Further Environmental Health Comments

From: Richard Stefanski
Sent: Friday, February 12, 2021 5:07 PM
To: Simon Davis <Simon.Davis@arun.gov.uk>
Cc: Alex Burrows [REDACTED]
Subject: RE: BR/8/21/RES

Subject: BR/8/21/RES

Drawing Title:  
**PROPOSED FLOOR PLANS**

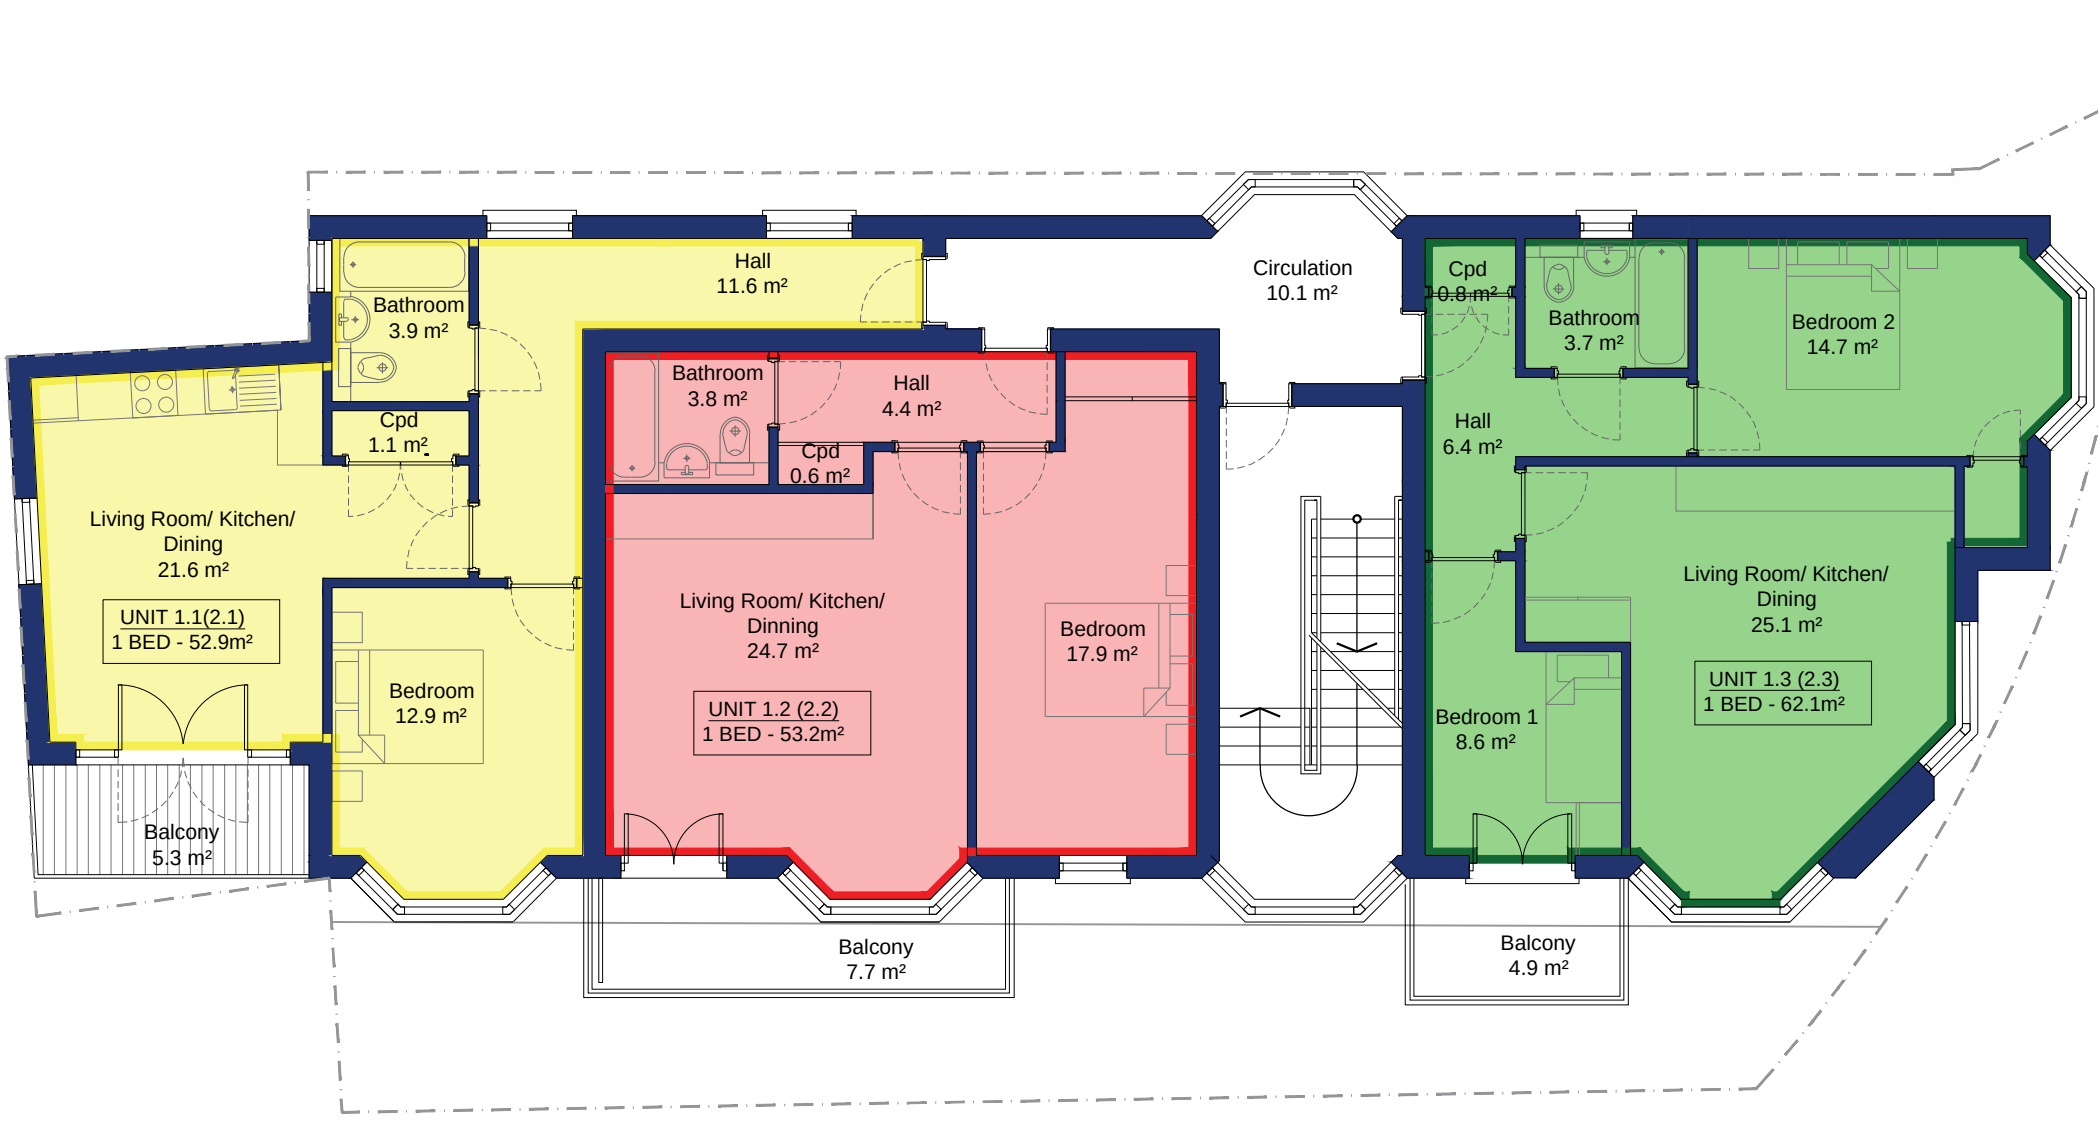
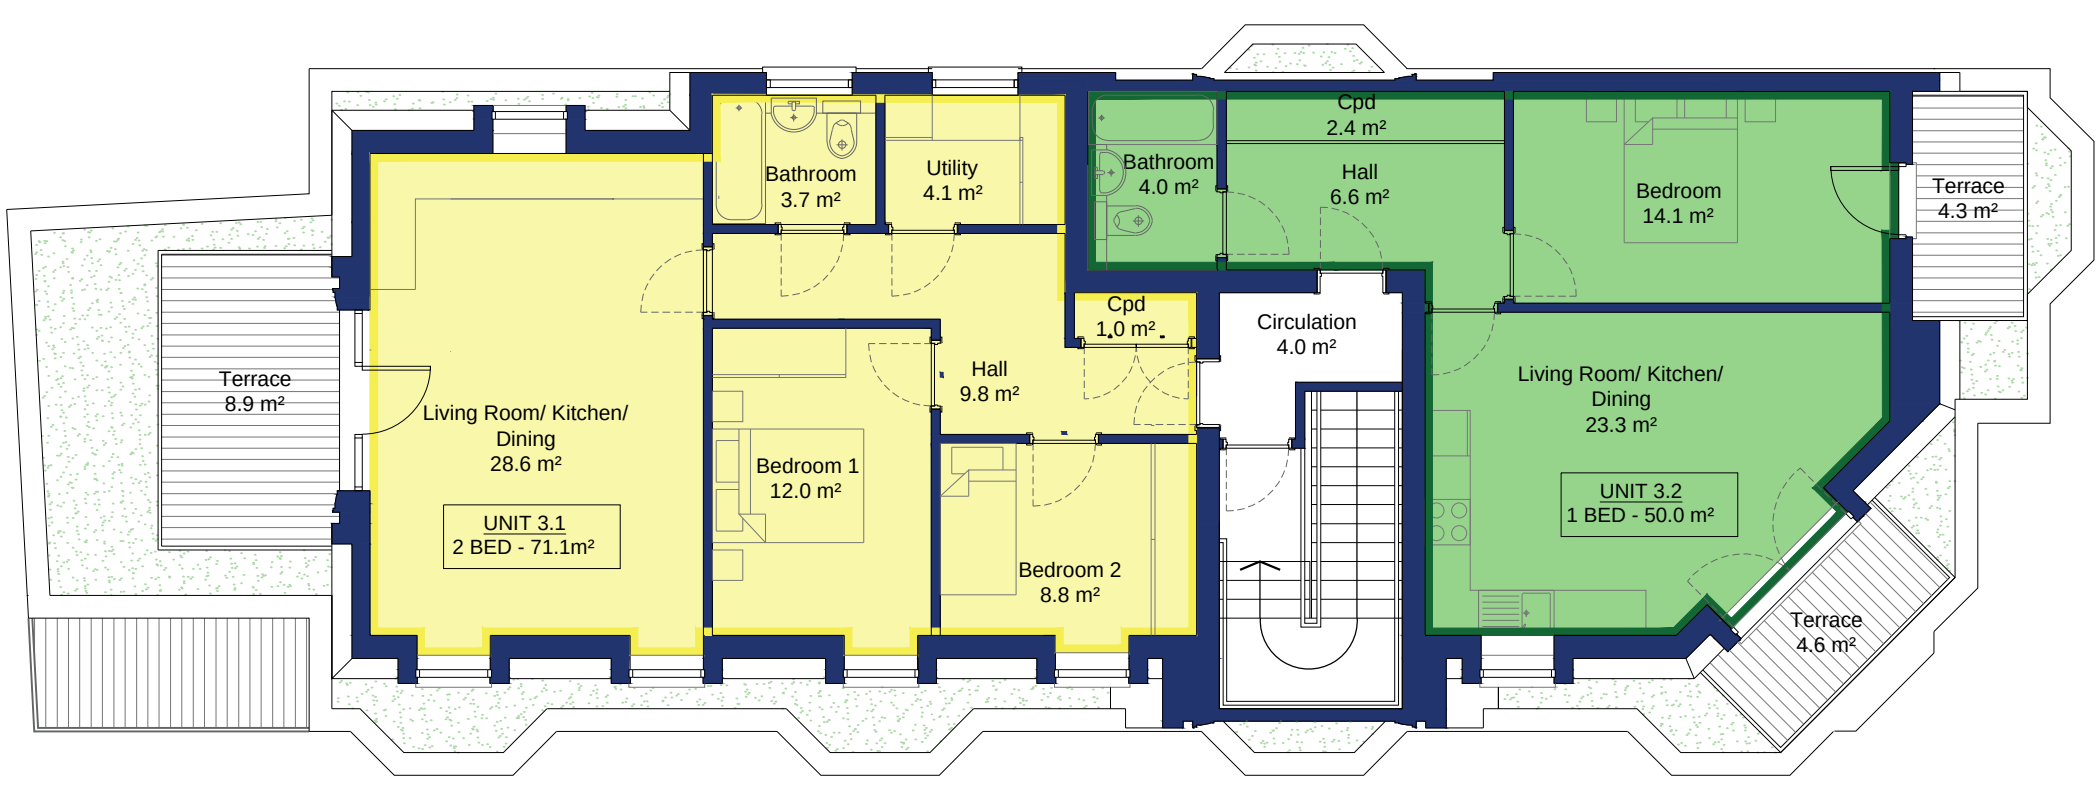
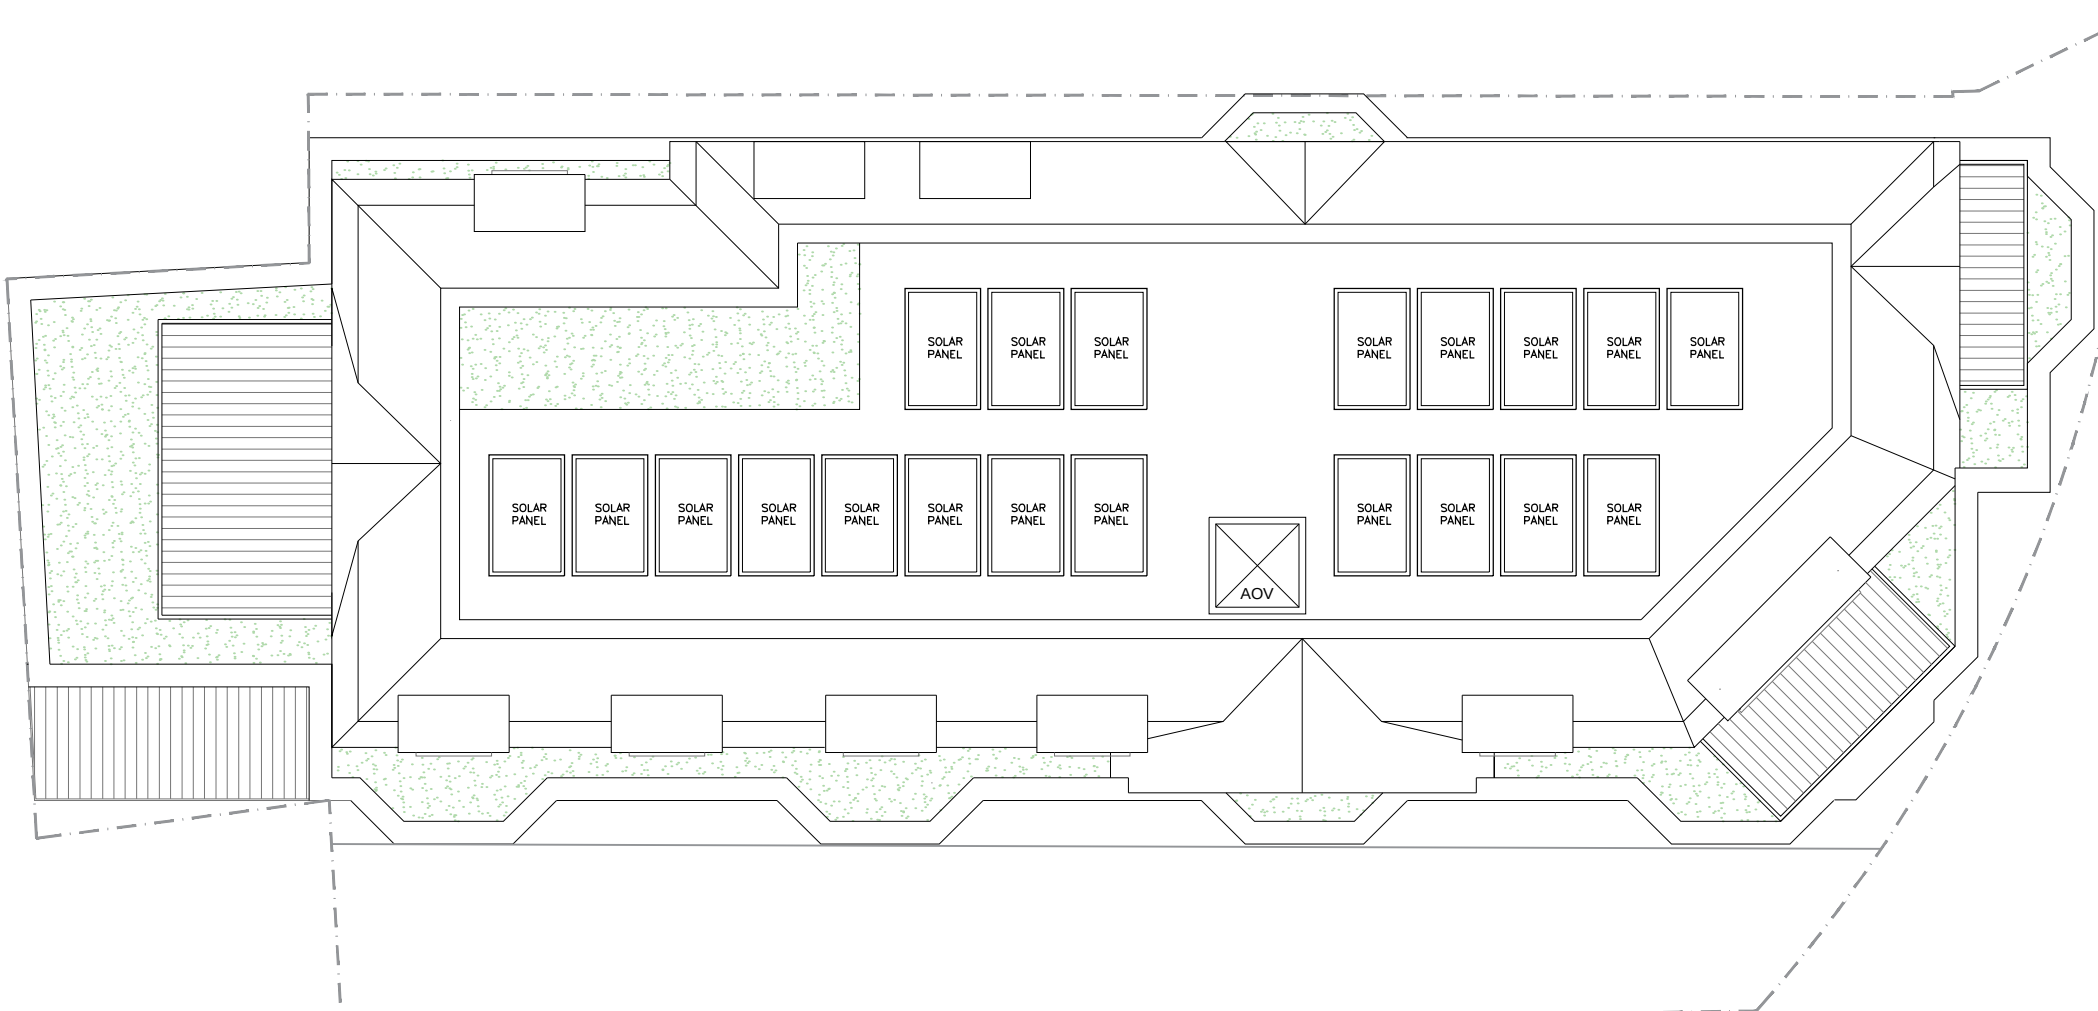
With reference to Environmental Health's comments on the original application (BR/142/18/OUT), Environmental Health objects to this application as the layout has habitable rooms facing the railway which will mean that BS8233 will only be met if the windows are kept closed. This application therefore does not follow the principles of good acoustic design within ProPG.

Please note that this was raised at the outline stage and indeed formed part of an informative 12 on the decision notice. I therefore write to request that you amend the floor plans/building layout to remove habitable rooms from the elevation backing onto the railway line. Please provide amended plans by the 17th February or if you need longer, advise me when you need until.

Unit G.1

- Floor plan revised. Adjusted from a 5-person 3 bed to a 4-person 2 bed.
- Window located in the living/kitchen dining, along the north west elevation, kept fixed shut, standard thermal double-glazing (which provides a sound reduction of RRAIL = 36dB) will be sufficient to ensure compliance with the requirements of BS8233 for daytime and night time periods. The room benefits from openable windows along the south east elevation. The windows are large enough to provide adequate purge ventilation.
- Bedroom 1 & 2 are located, with openable windows along the south east elevation.

- Window located in the living/kitchen dining, along the north west elevation, kept fixed shut, standard thermal double-glazing (which provides a sound reduction of RRAIL = 36dB) will be sufficient to ensure compliance with the requirements of BS8233 for daytime and night time periods.. The room benefits from openable windows along the south east, and south west elevation. The windows are large enough to provide adequate purge ventilation.

It should be noted that the attached design, in most cases, uses buffer-zones to protect habitable rooms. The buffer-zone is created using bathrooms, utility, kitchens, and halls. They are used in this design on the most exposed elevation. In addition, further to this recent adjustment, no bedrooms have windows within the north west elevation.
